Recommendation Report for Works to Tree(s) on trees subject to a Tree Preservation Order (TPO)

REF NO: LU/150/19/T

LOCATION: Apple Tree Cottage
Toddington Lane
Littlehampton
BN17 6JX

PROPOSAL: Fell 1 No. Robinia & reduce crown of 1 No. Holm Oak by 2m.

Apple Tree Cottage Bn17 6JX

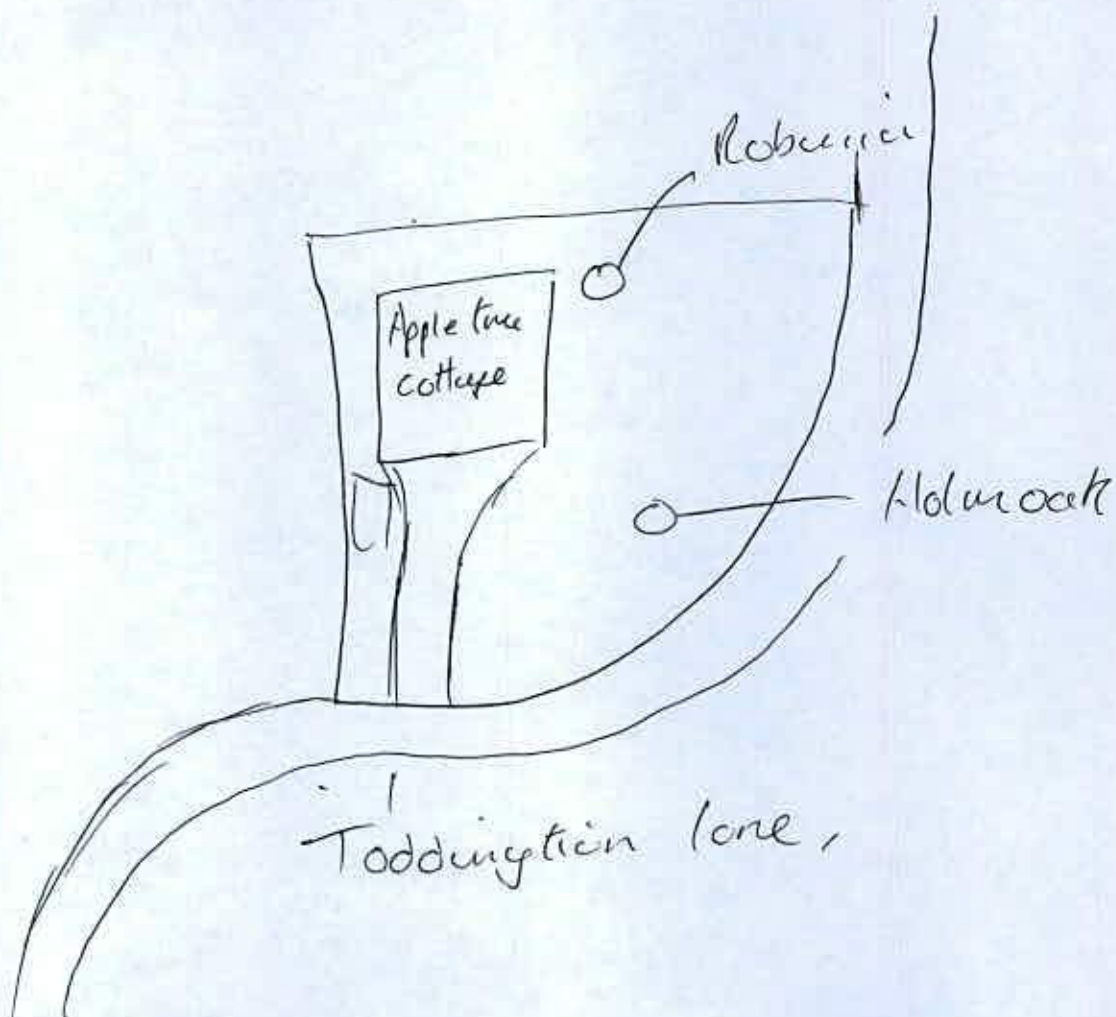
T1 False acacia / Robinia pseudoacacia Approx. height: 11m Average spread: 3m Age class: Over mature

T2 Holm oak / Quercus ilex Approx. height: 12m Average spread: 6m Age class: Early mature

T1 - Appears to be in a fair physiological state and of moderate form, having been previously 'topped' at 4metres height and with an uneven limb and branch recovery. This is clearly a tree in slow but inexorable decline and having become unsuitable for its location. It is visible from adjacent properties but only with difficulty from publicly accessible land.

T2 - Appears to be in a fine physiological state and of moderate form, having been suppressed a little by

the adjacent established large pine trees. While of some visual interest it is clearly subordinate to the pine trees which are of much greater value. A re-balancing of the crown profile is unlikely to improve the tree's long-term prospects but would introduce some formality to this part of the garden.

I recommend CONSENT for this application, subject to the following conditions:

Where whole branches are to be removed and final cuts made close to the trunk or branch union they are to be made as shown in Figure 2 of BS3998:2010

Where branches are to be shortened back the final cuts are to be made at the correct angle shown in BS3998:2010 and adjacent to a live bud or lateral.

The long-term vitality of tree T2 is best respected when significant pruning work such as proposed, is undertaken during the mid to late-winter period (January to February). The work proposed must only be undertaken during this period.
